**Conditions of development consent for the Sydney Metro Martin Place Station Precinct  
SSD 9270 – North Site**

***Condition B5, B6 and B7 discharge request #6 – Design excellence and design integrity review***

# Level 01 Plan

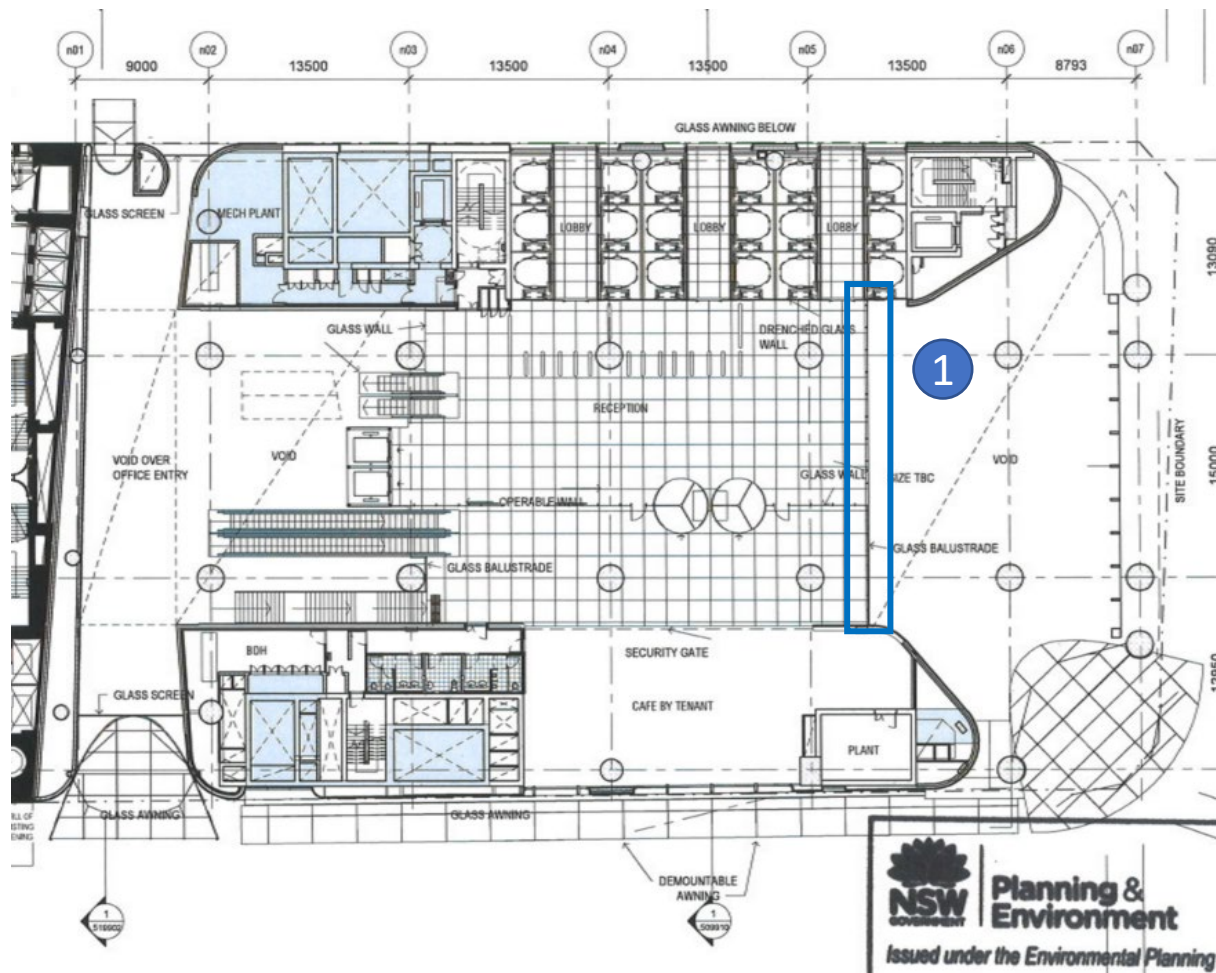
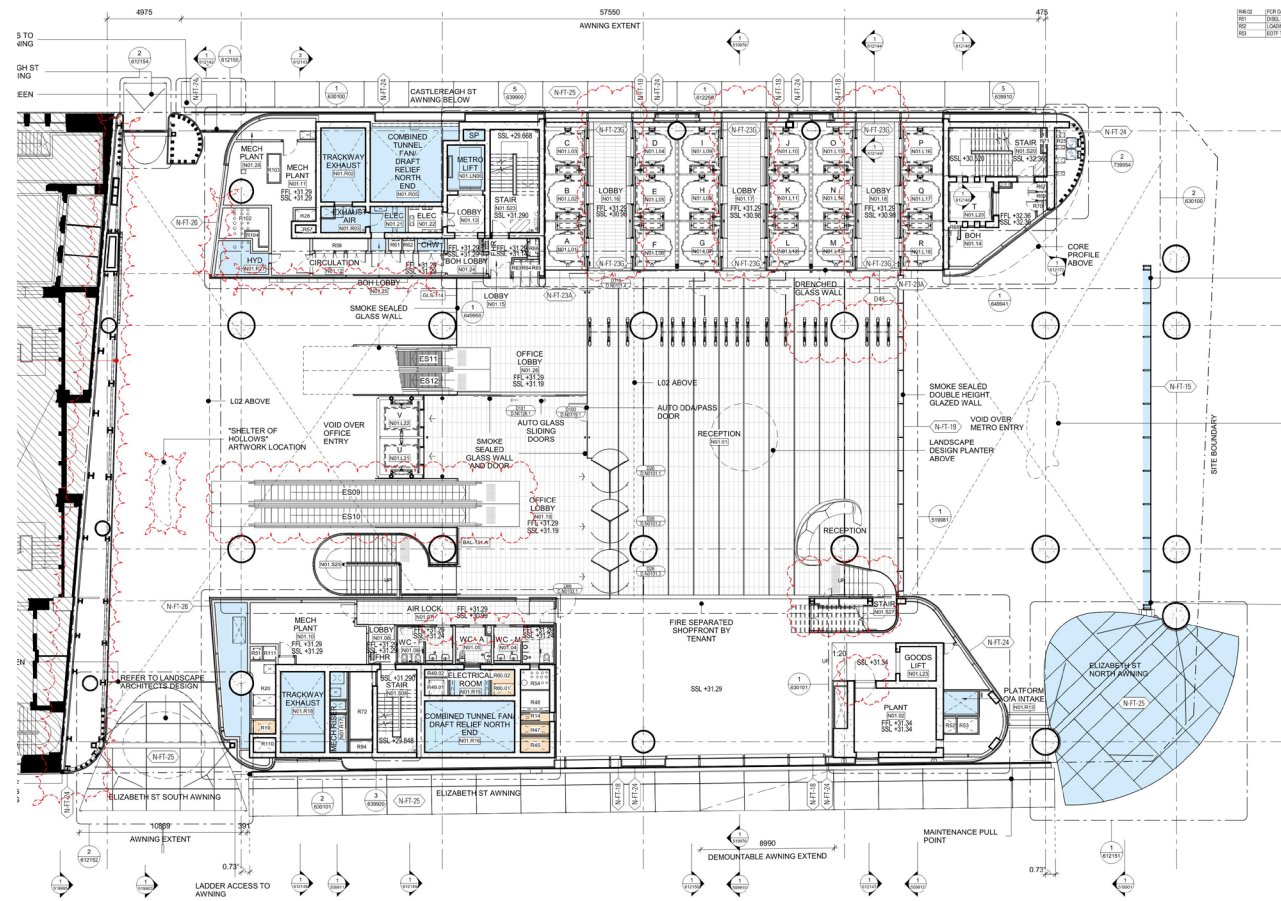
Attachment reference	Design change	OSD DRP engagement approach
<b>Level 1 &amp; 2</b>		
Att A Slides 2 & 3	Alteration of approved open balcony to include full height clear glazing to the northern end of lobby on Levels 1 and 2.	OSD DRP review is not considered necessary on the basis the proposed change is wholly internal and will not result in any changes to the exterior of the building.
<b>Level 5</b>		
Att A Slide 4	Minor alterations to arrangement of plant and services comprising relocation of tenant plant from Level 5 to Level 6.	OSD DRP review is not considered necessary on the basis the proposed change is wholly internal and will not result in any changes to the exterior of the building.
<b>Level 6</b>		
Att A Slide 5	Minor alterations to arrangement of plant and services on Level 6 and inclusion of tenant plant previously on Level 5.	OSD DRP review is not considered necessary on the basis the proposed change is wholly internal and will not result in any changes to the exterior of the building.

# Upper Roof Plan

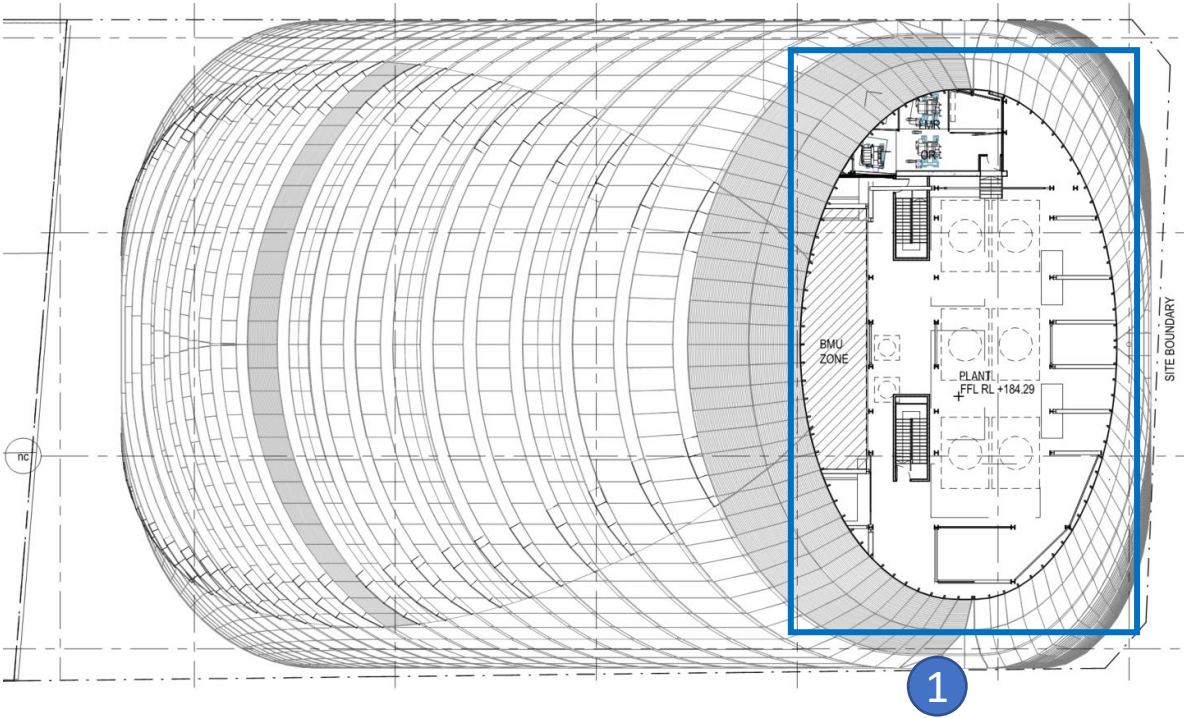
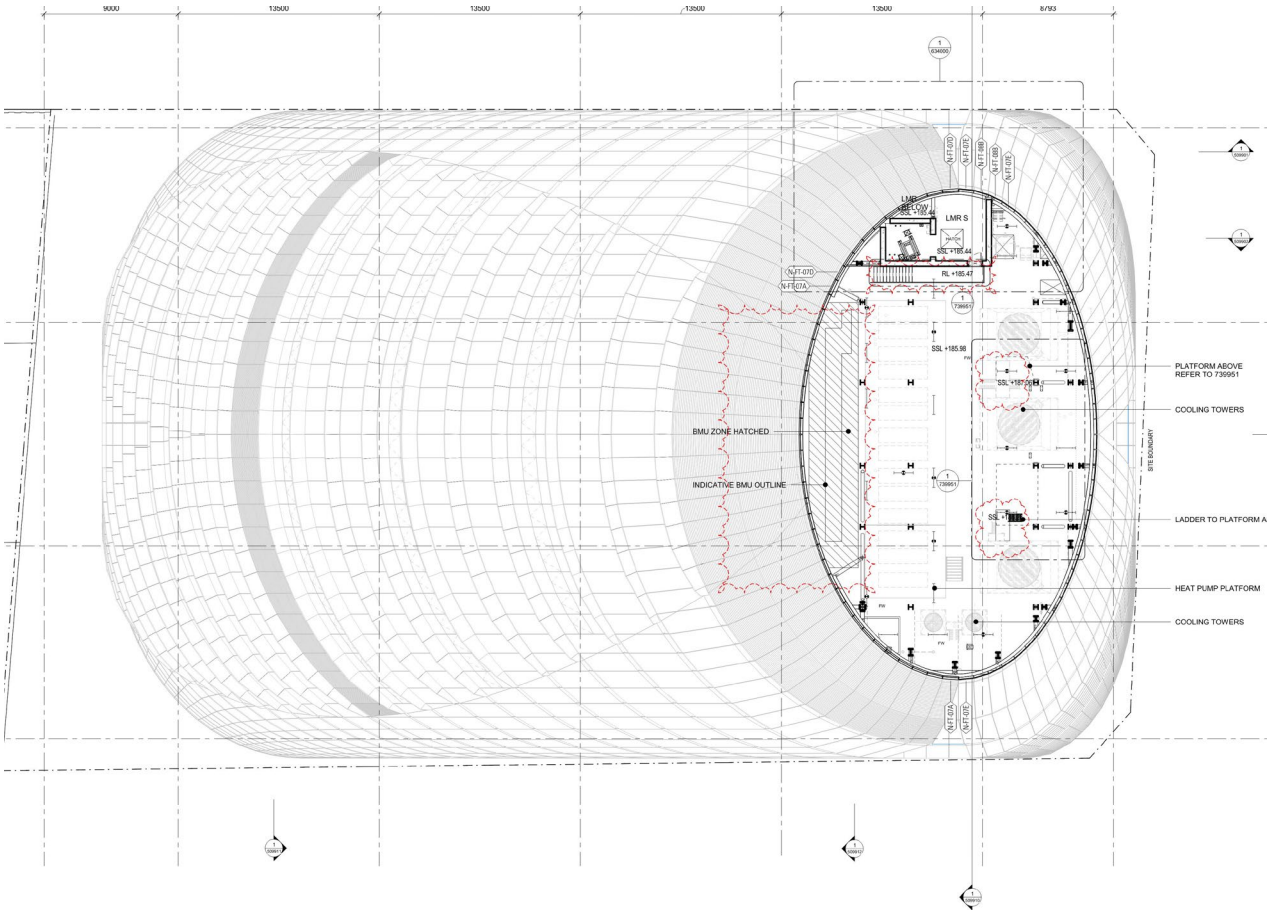
<b>Upper Roof</b>		
Att A Slide 6	Lowering of finished floor level (FFL) on Upper Roof.	OSD DRP review is not considered necessary on the basis the proposed change is wholly internal and will not result in any changes to the exterior of the building.
<b>West Elevation</b>		
Att A Slide 7	Increase in louvres on Levels 15 and 28 in lieu of glazing on western façade.	<p>OSD DRP review is not considered necessary on the basis the proposed change is minor and constitutes only a minor increase of existing louvres on Level 15 and 28. The design change will have a negligible impact on the overall northern façade design.</p> <p>The inclusion of additional louvres is justified given it will mask the following from views of the building:</p> <ul style="list-style-type: none"> <li>• The termination/interface of the fire separation to the facade in the form of speed panel.</li> <li>• Spatial constraints require the lifting switch boards to be positioned adjacent to the façade.</li> <li>• Complex floor structure and services bulkheads to the ceiling.</li> <li>• Elements of structural steel work which required fire proofing will be visible through facade.</li> </ul> <p>From a design perspective, replacing the glazing panels with louvres is recommended by JPW as the change improves the western facade in that provides a consistent vertical plane with the above floors and eliminates view into the servicing elements noted above.</p> <p>A comparison of the currently approved and proposed design change on the western façade is provided at <b>Figures 1 and 2</b>. Further detail is also provided in the Architectural Design Statement at <b>Attachment B</b>.</p>
